From: Anita Gardner
Sent: 28 August 2019 14:02
To: Planning.Responses <Planning.Responses@arun.gov.uk>
Subject: FW: 22 Beach Road, Littlehampton.
Importance: High

Subject: 22 Beach Road, Littlehampton.

I write further to the client providing me with your feedback on the AASL acoustic report dated 6th June 2019 for the above site.

Figure 4. Internal Measurement Positions

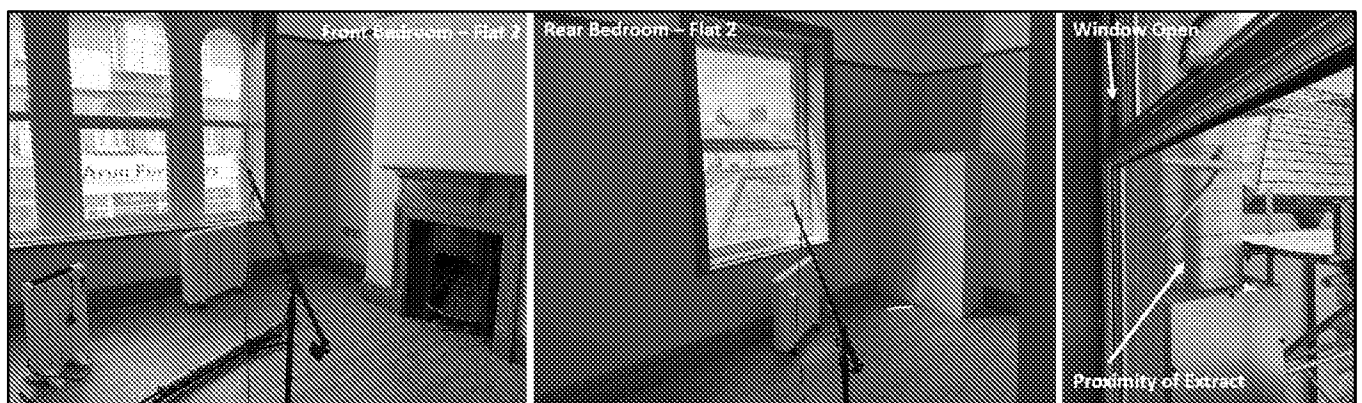
The reverberation times were measured in each of the locations where the surveys were undertaken. As noted from Table 3 in the report, the front bedroom in flat 2, was considerably higher in terms of reverberation than the smaller two bedrooms measured. As per Figure 4 of the report, the image displayed on the left hand side shows the laminated floor already laid.

When the bedroom is lived in and furnished with curtains, beds, pillows and duvets etc, the reverberation time will inevitably decrease and in this case a final reverberation time of 0.5s as was used in the calculations (This is what the Building Regulations state will be the average reverberation time for a furnished room). In this instance the correction used was 3dB as the empty surveyed rooms had an average reverberation time of 1s

Figure 7. Review of 1-hour periods inside Flat 1 bedroom

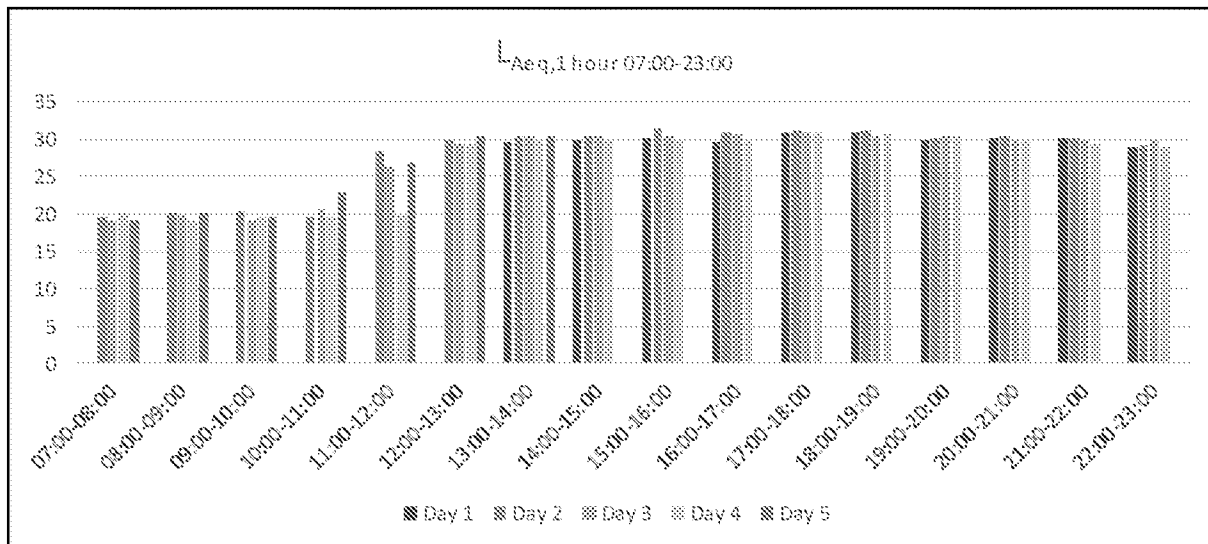
Figures 6 and 7 in the report relate to Flat 1, however the references to 39 and 44dB relate to Flat 2, front bedroom, which is reported in Figure 10.
